Objection to Planning Application 3/2023/0339 - Annex to Cuttock Clough House, Mill Lane, Waddington

We write in objection to the planning application at the Annex at Cuttock Clough House (LPA ref 3/2023/0339).

Proposed & Existing Site Plan - 1:500

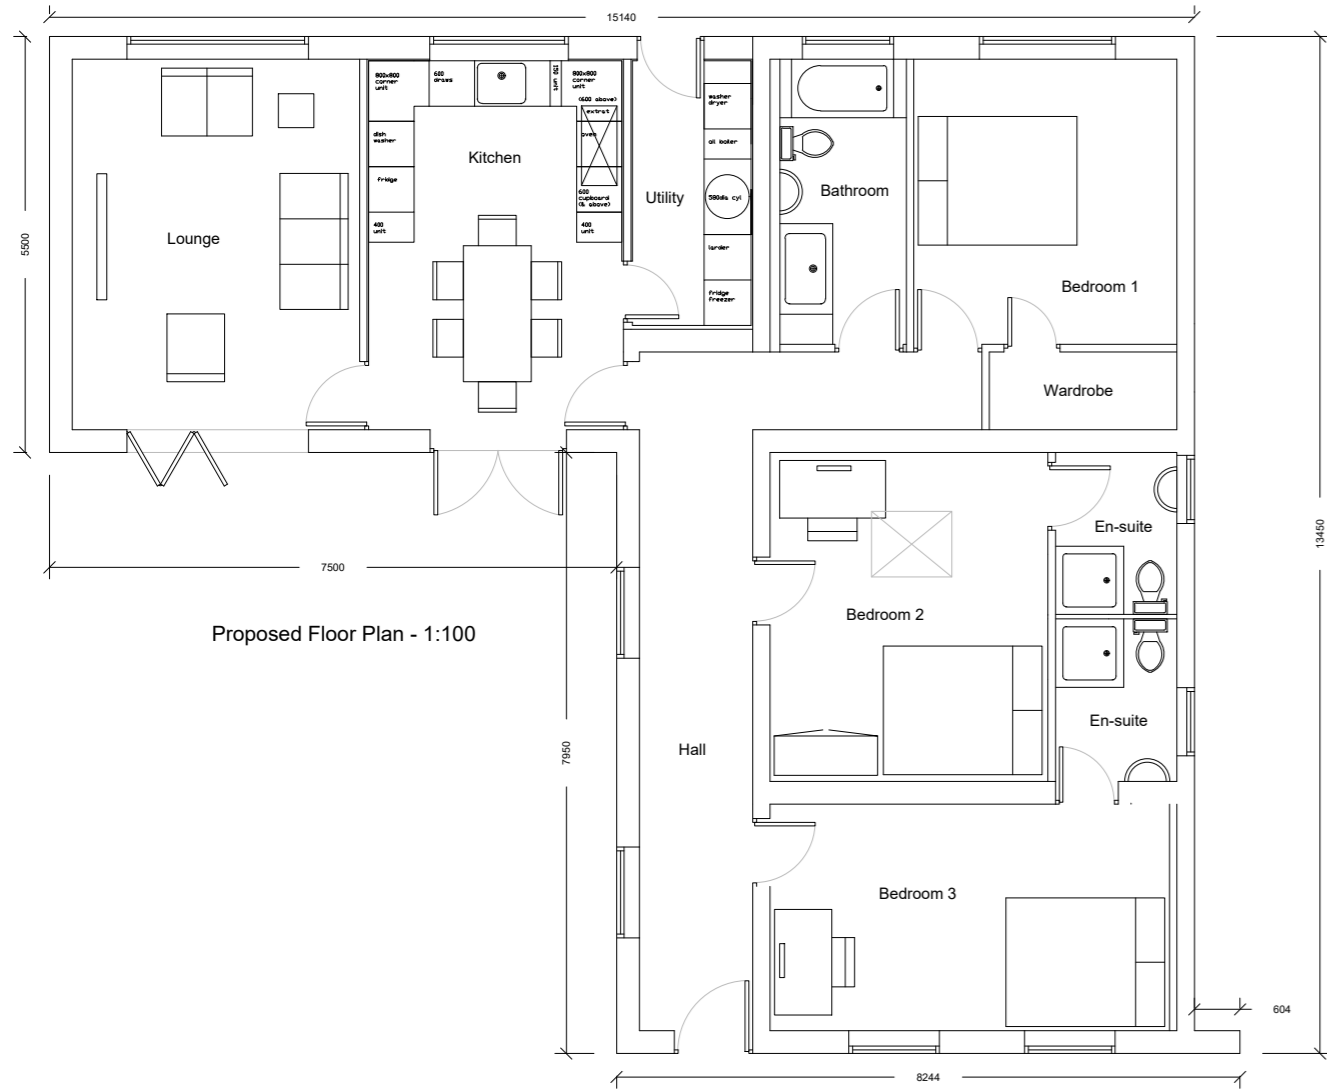
The submitted site plans do not annotate [REDACTED] It could therefore be misinterpreted that [REDACTED]

The assigned ownership boundary runs directly between the Annex and [REDACTED] building indicated for the potential use of strangers visiting the holiday let. [REDACTED] that provides [REDACTED] There is no indication of a formal boundary

The Annex is effectively landlocked with sole access shown [REDACTED]
[REDACTED] A commercial use of the Annex does not have any access rights [REDACTED] therefore cannot be delivered.

It seems it is then proposed to create a new access route across the direct frontage of the Annex building, right in front of bedroom 3 windows and the main front door access into the Annex, to a newly created parking area to the west of the building. We question whether there is sufficient land width to create a vehicular access across the front of the Annex. We also question whether there is sufficient space to manoeuvre vehicles from the hatched area [REDACTED] that frontage access strip without [REDACTED]

There is also a change in levels [REDACTED] to the proposed frontage access strip therefore we would question how the access is to be created without undermining the Annex foundations, how visitors would step up into the Annex front door (as any steps would conflict with the access route for vehicles), and whether existing/ proposed drainage requirements in this area would be affected by the change in levels required.

We also question whether strangers would be aware of the access route and requirement to pass by the building to access the proposed parking area (that would be hidden by the Annex) and instead [REDACTED] or on the narrow Mill Lane, all of which could create issues. Any requirement for signage to direct visitors would be [REDACTED] and be unnecessary clutter and visually harming and incongruous [REDACTED]

Proposed Floor Plan - 1:100

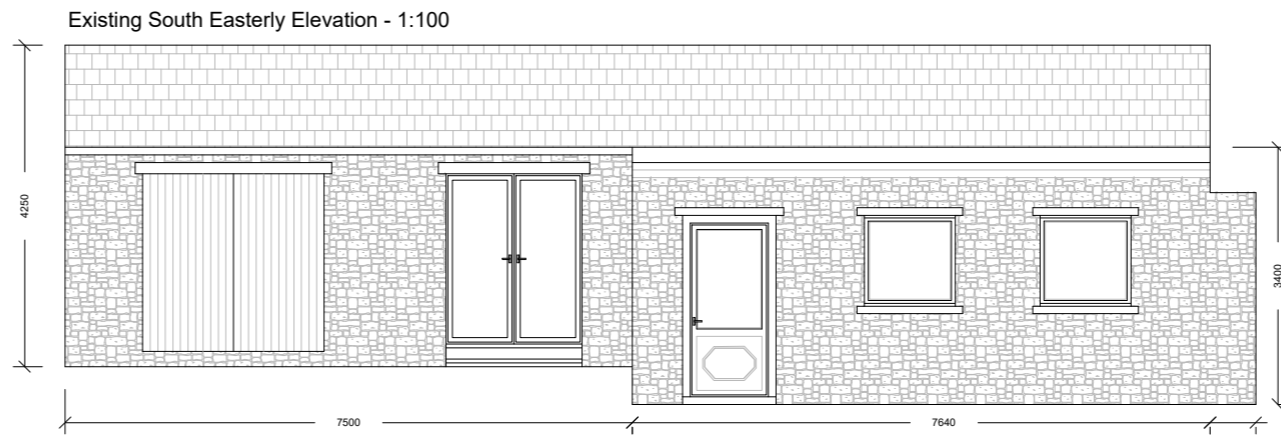
The proposal includes increasing the number of bedrooms and living space in the building and to increase the provision from 1 to 2 cars. This would therefore allow for 6+ people to visit the building, a material uplift from the that the building could likely have accommodated previously.
